From: Lauren Willard [REDACTED]
Sent: 04 August 2015 12:46
To: David Easton
Subject: RE: EP/91/15/HH - 7 Seaview Road

From: David Easton [<mailto:David.Easton@arun.gov.uk>]
Sent: 28 July 2015 15:25
To: [REDACTED]
Subject: EP/91/15/HH - 7 Seaview Road

SECOND FLOOR PLAN

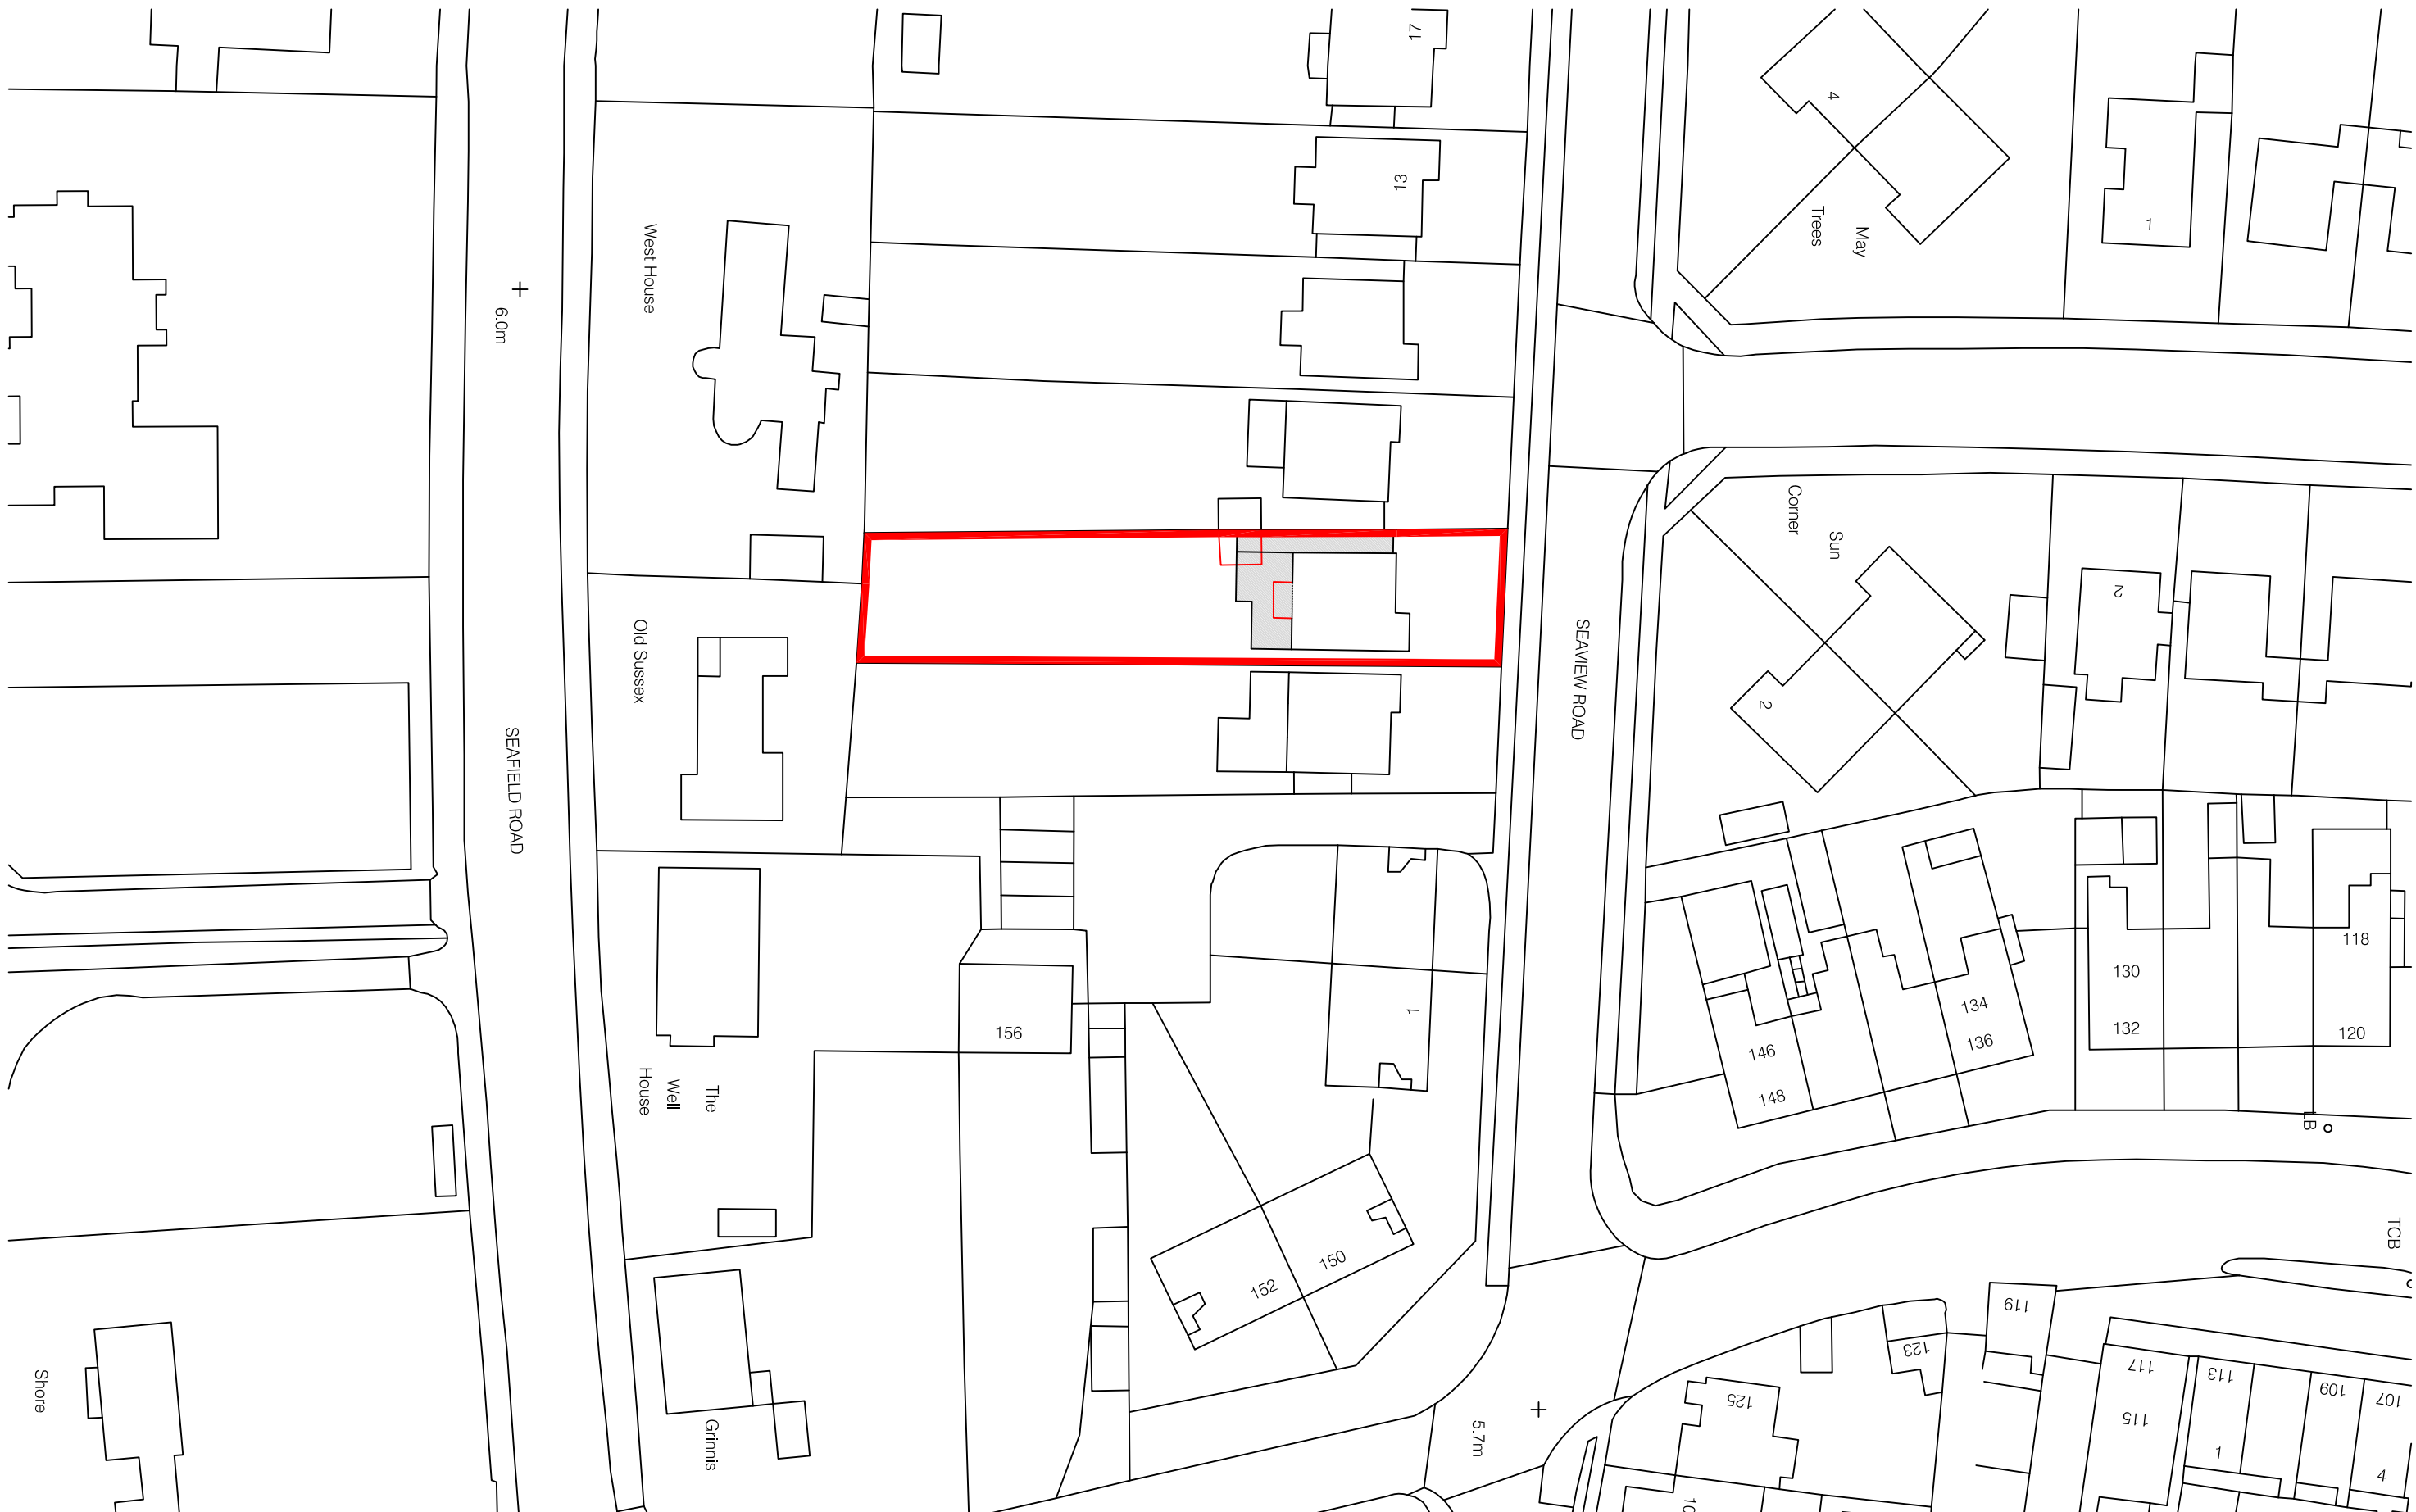
I remain concerned in relation to the proposed roof design (regardless of the presence of the dormer window) due to its proposed layout and shape and the impact this will have upon the character of the dwelling. I can also confirm that having spoken with my team leaders in relation to this application they are also of the opinion that the proposal due to the design of the roof will not appear subservient or integrated with the host dwelling.

Have you take into account the roofs to be created above the proposed two storey rear extension as this must also be taken into account of the roof space created. I have calculated the rear roofs as totalling 29.7m³ which when added to my gable calculation of 23.48m³ gave the total of 53.21m³.

Please find attached revised drawings which have had the alterations to the existing roof omitted.

ELEVATIONS (1:100)

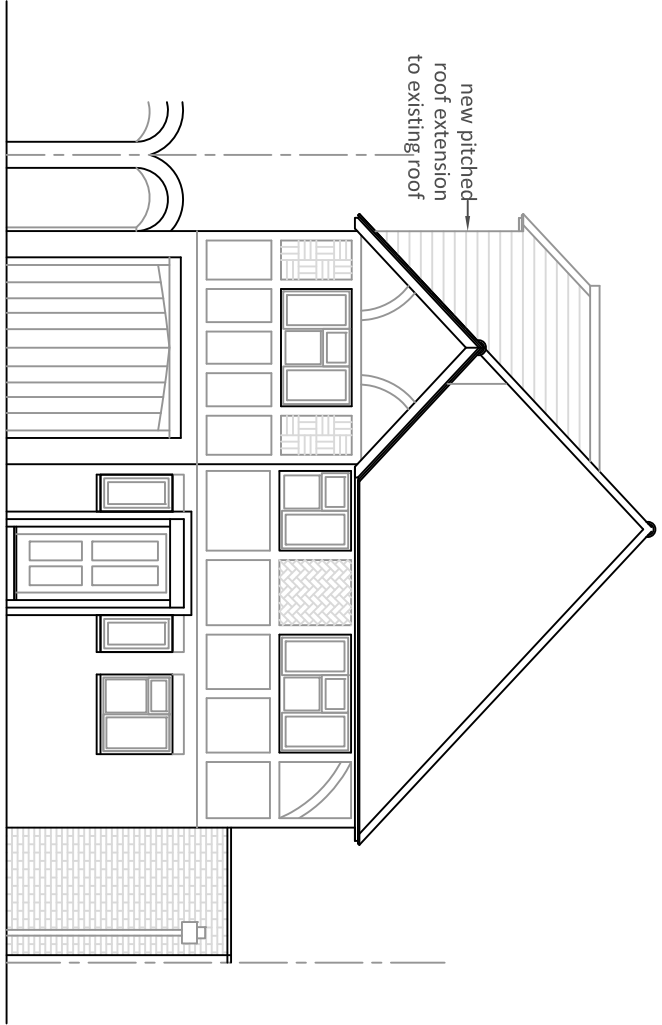
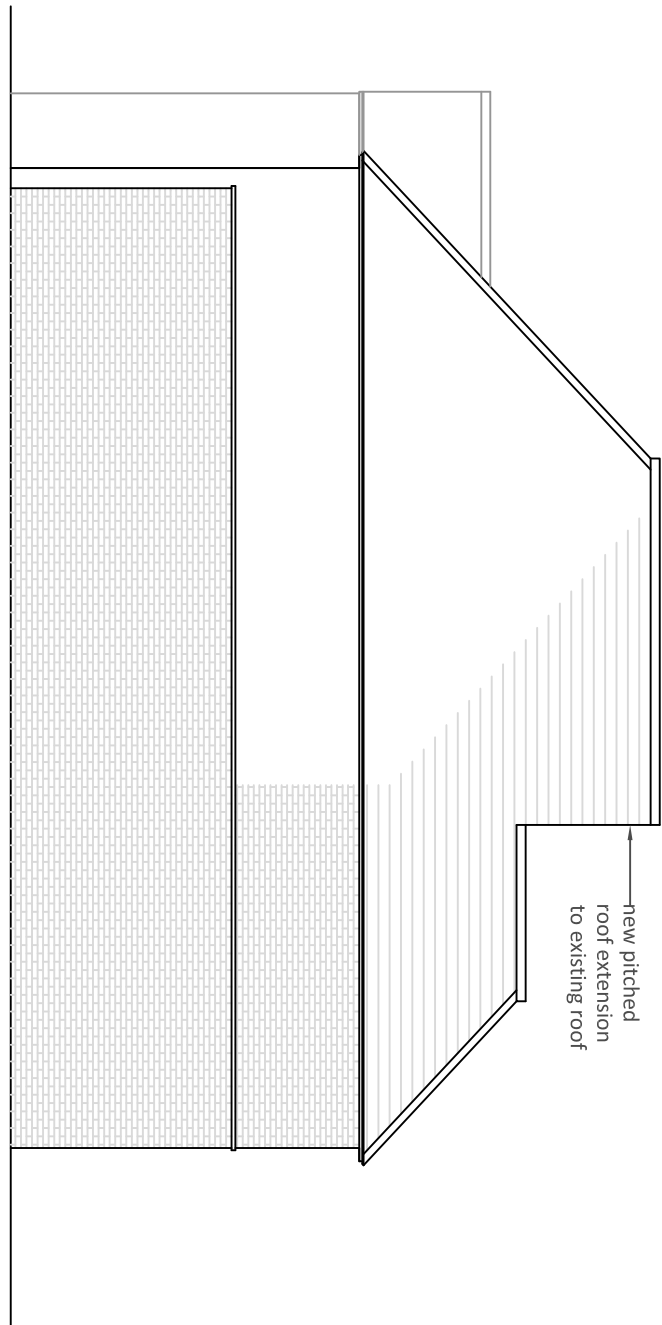
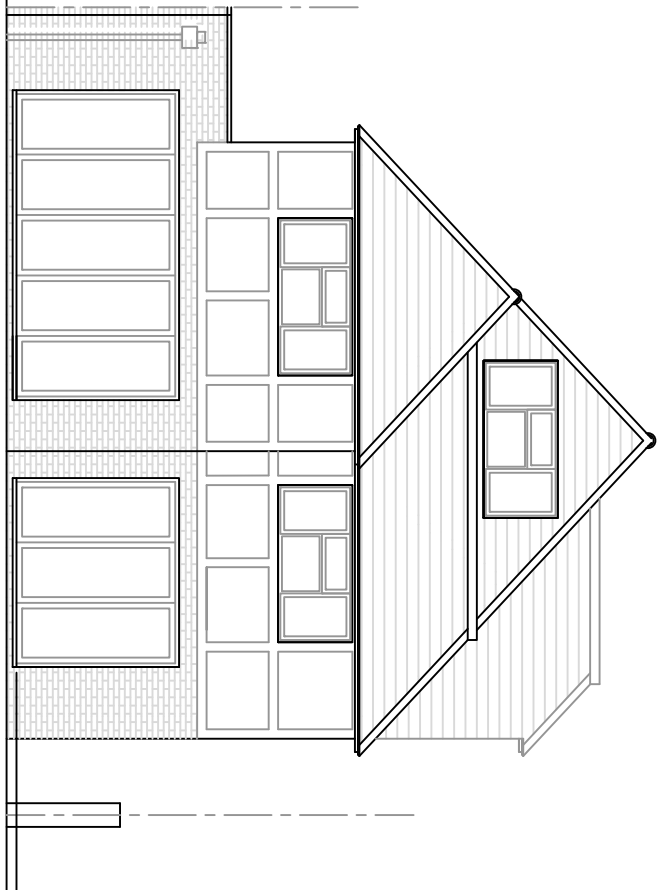
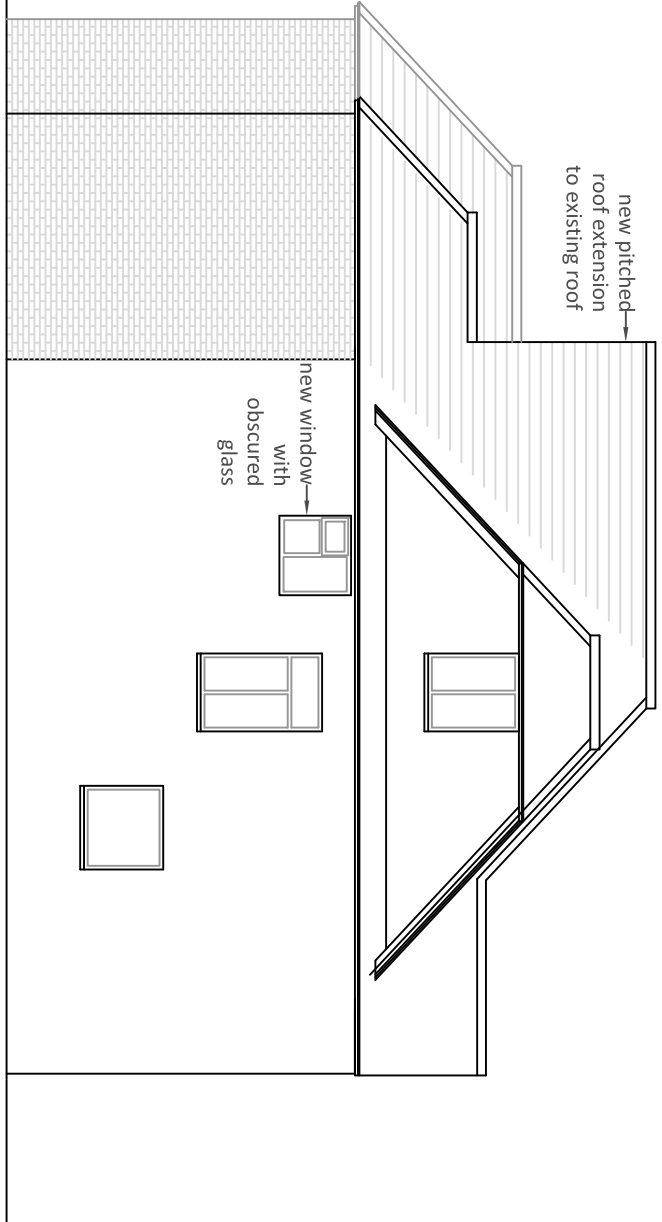
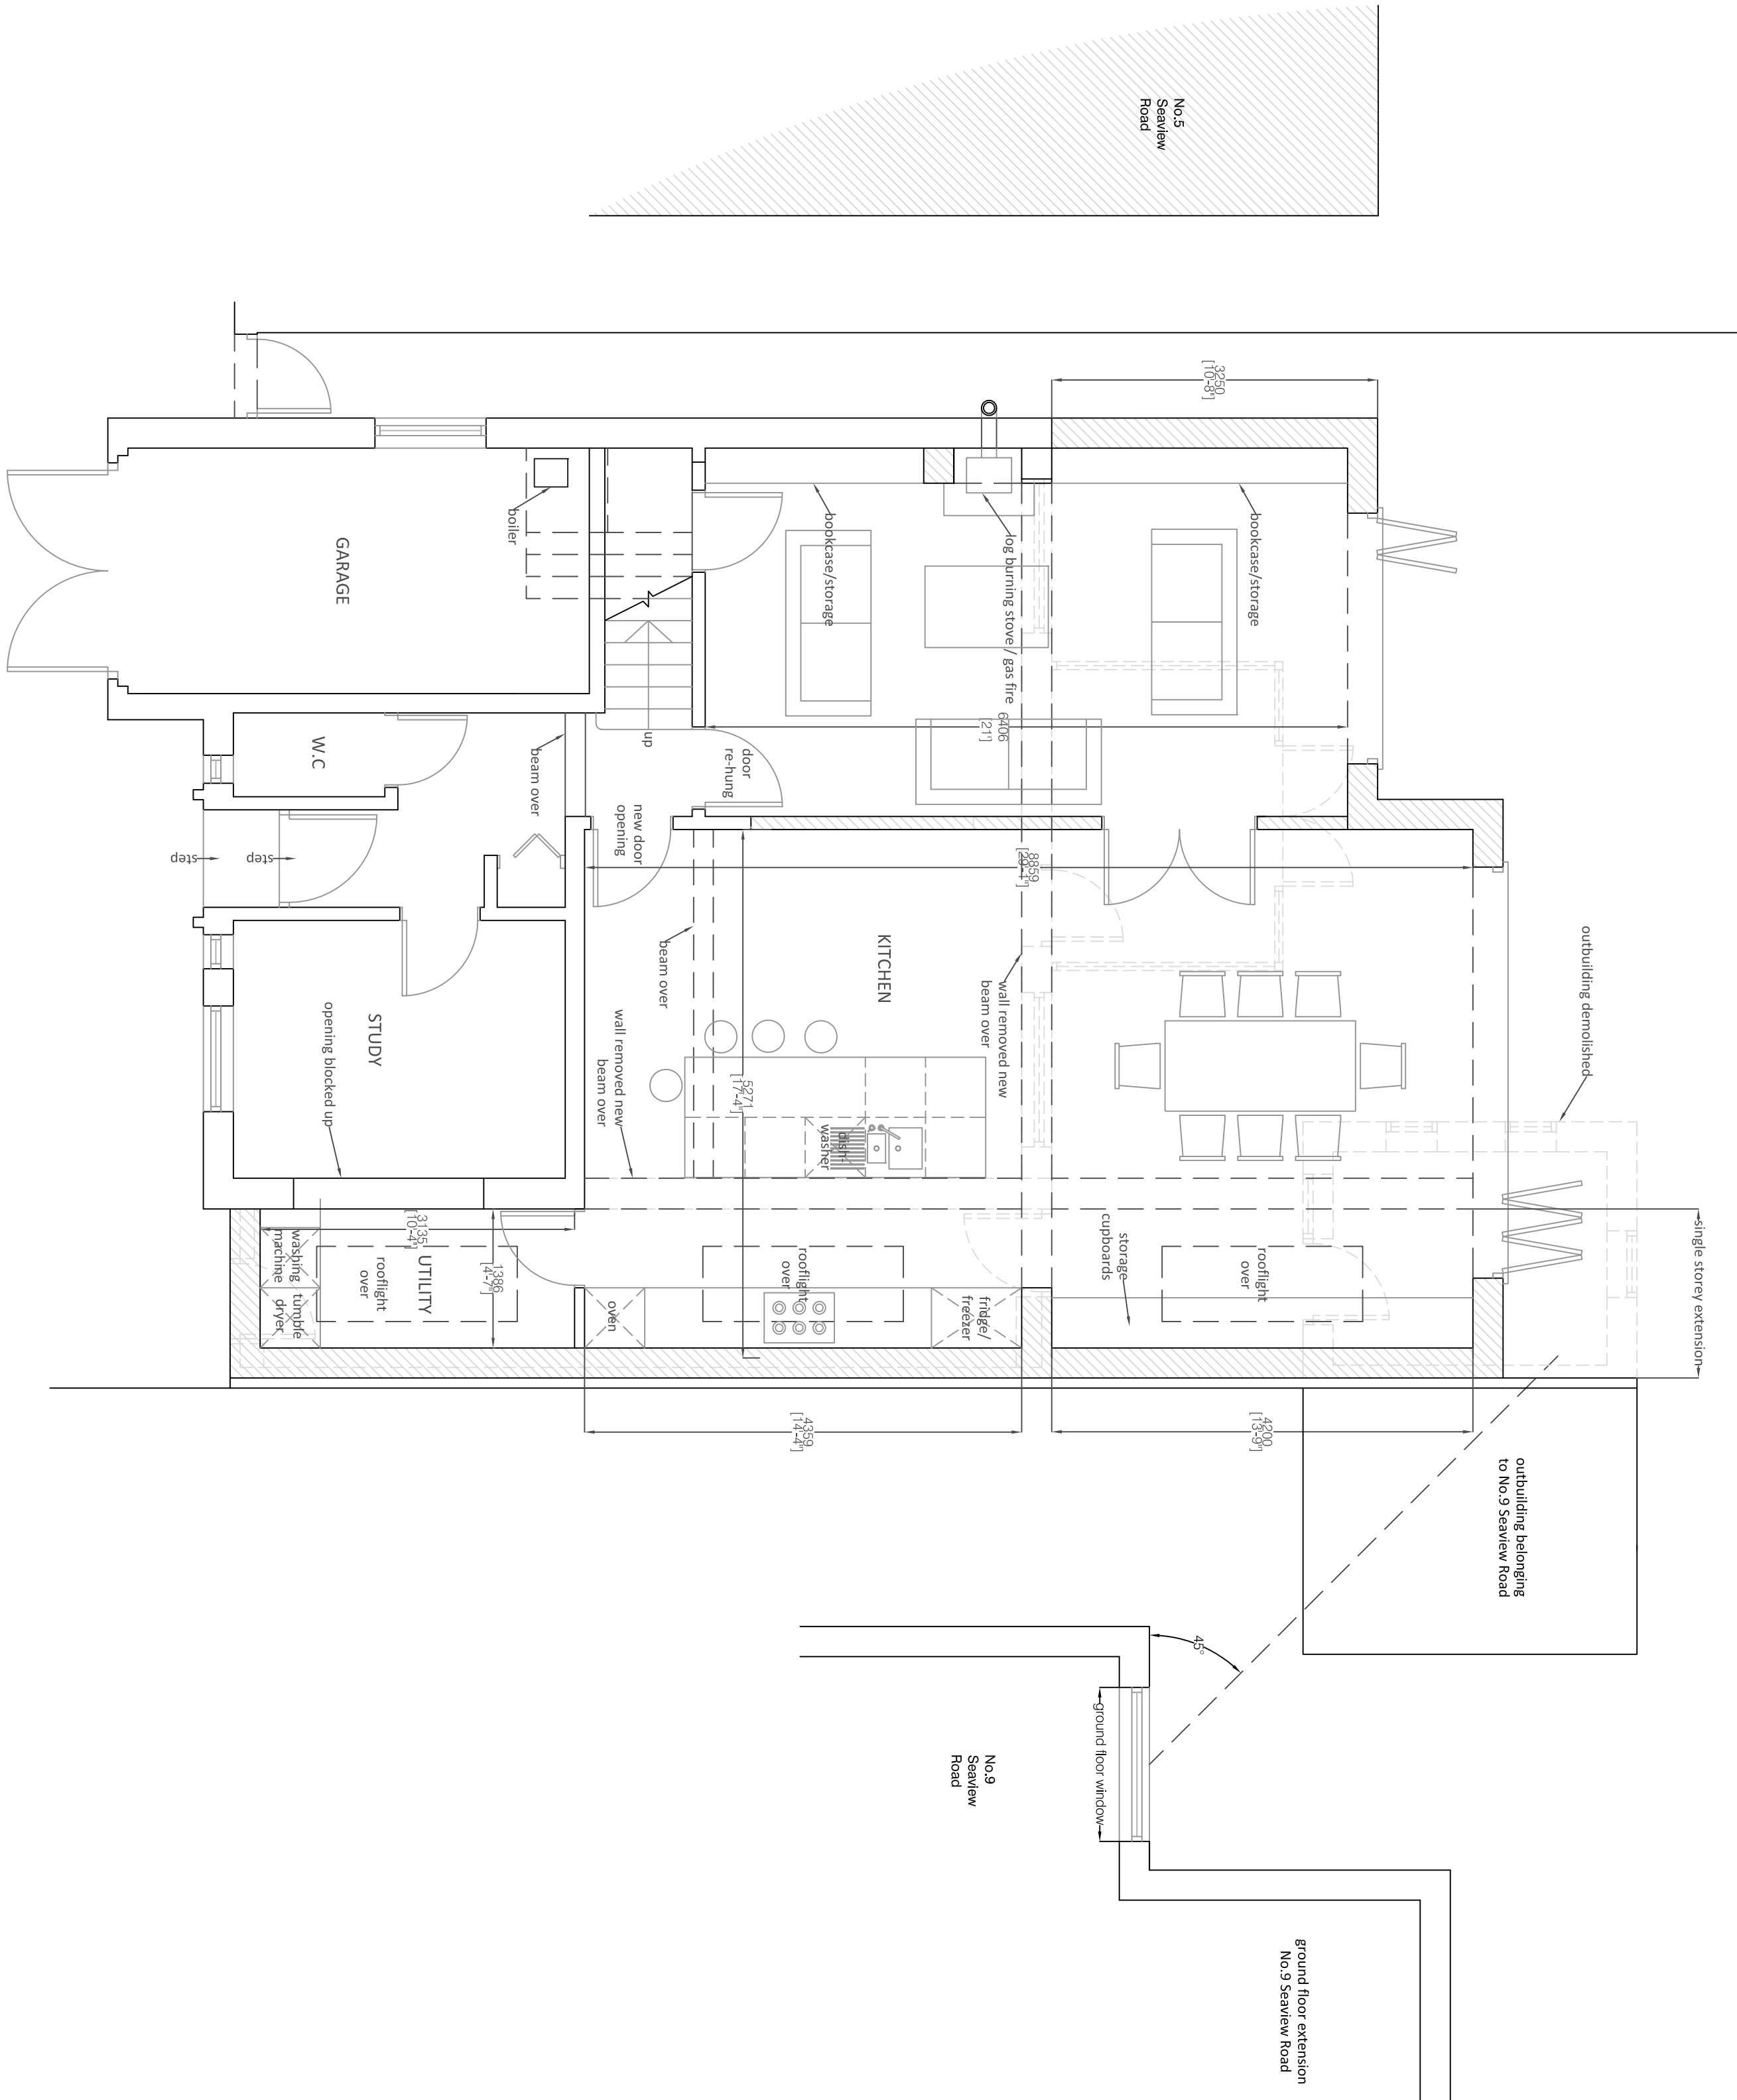
I have had an opportunity to look at this application in greater detail. I would firstly state that the proposed roof alterations to the rear and dormer to the side of the dwelling are considered to be in conflict with policies GEN7 (ii) and DEV19 (i) & (ii) of the Arun District Local Plan. This determination has been reached as the design of the gable

end is considered to adversely impact upon the established character and appearance of the dwelling. Therefore, the proposed alterations to the roof do not appear well integrated or subservient to the host dwelling due to the design of the roof. The proposed dormer window on the side of the dwelling is also considered to conflict with policy DEV19 (v) due to its impact upon the street scene.

When we spoke this morning you referred to the removal of the dormer window from the application as it could be constructed under permitted development rights. I have briefly examined the plans and calculated that the volume of the proposed roof alterations (excluding the dormer window) are approximately 53.21 metres cubed – if this calculation is incorrect please don't hesitate to send me your own calculations for the roof space created.

Therefore, due to the size of the amount of roof space created no further additions or alterations could be made to the roof under Schedule 2, Part 1, Class B of The Town and Country Planning (General Permitted Development) Order 2015 and the dormer would require planning permission.
